June 18, 2024

Subject: **CAMA Major Development Permit Modification** for the Proposed Replacement of Bridge No. 9 on SR 1112 (Mouth of The Creek Rd) over Blounts Creek in Beaufort County, North Carolina; TIP No. B-5614; WBS No. 45569.1.2.

The Department requests modification for utilities installation for B-5614.

**BUFFER DRAWING
SHEET 2 OF 5**

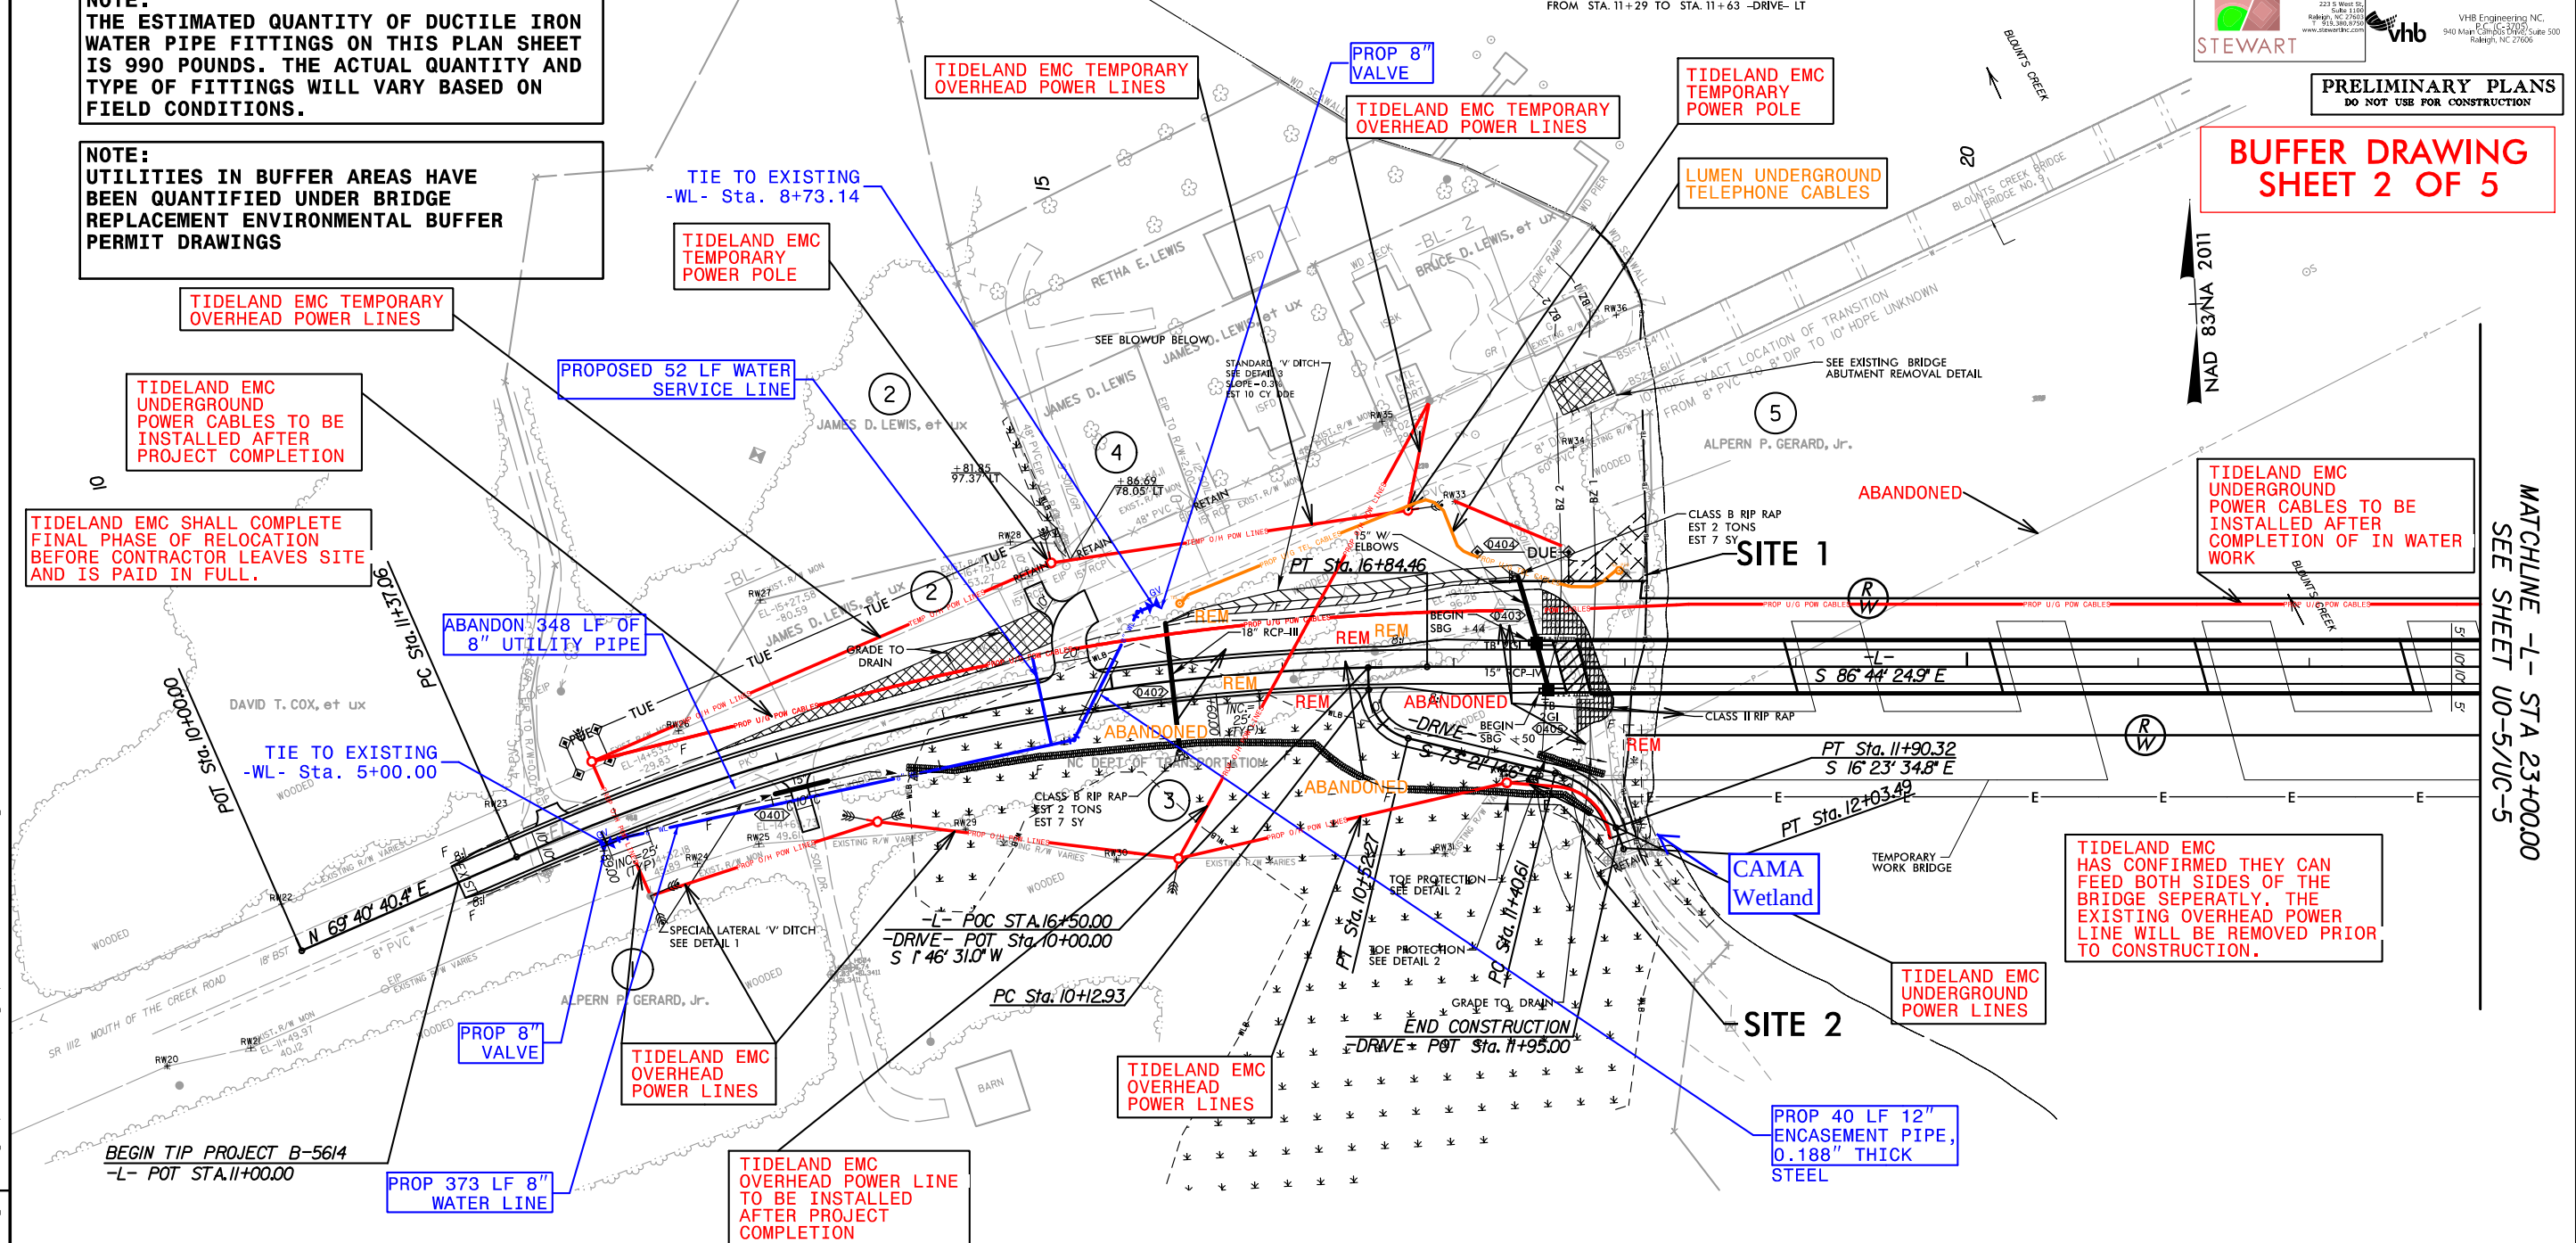
The shift of the utility pole location will require an additional 0.01 acres of hand clearing in wetland at Site 2, increasing the total hand clearing impacts from 0.15 to 0.16 acres. The shift of the utility pole will also require an additional 7 square feet of impact in Buffer Zone 2. The increase in buffer impacts at Blounts Creek makes the new total of Buffer Zone 2 impacts 112 square feet. In as much, there will be a reduction in Buffer Zone 1 impacts decreasing from 203 to 0 square feet.
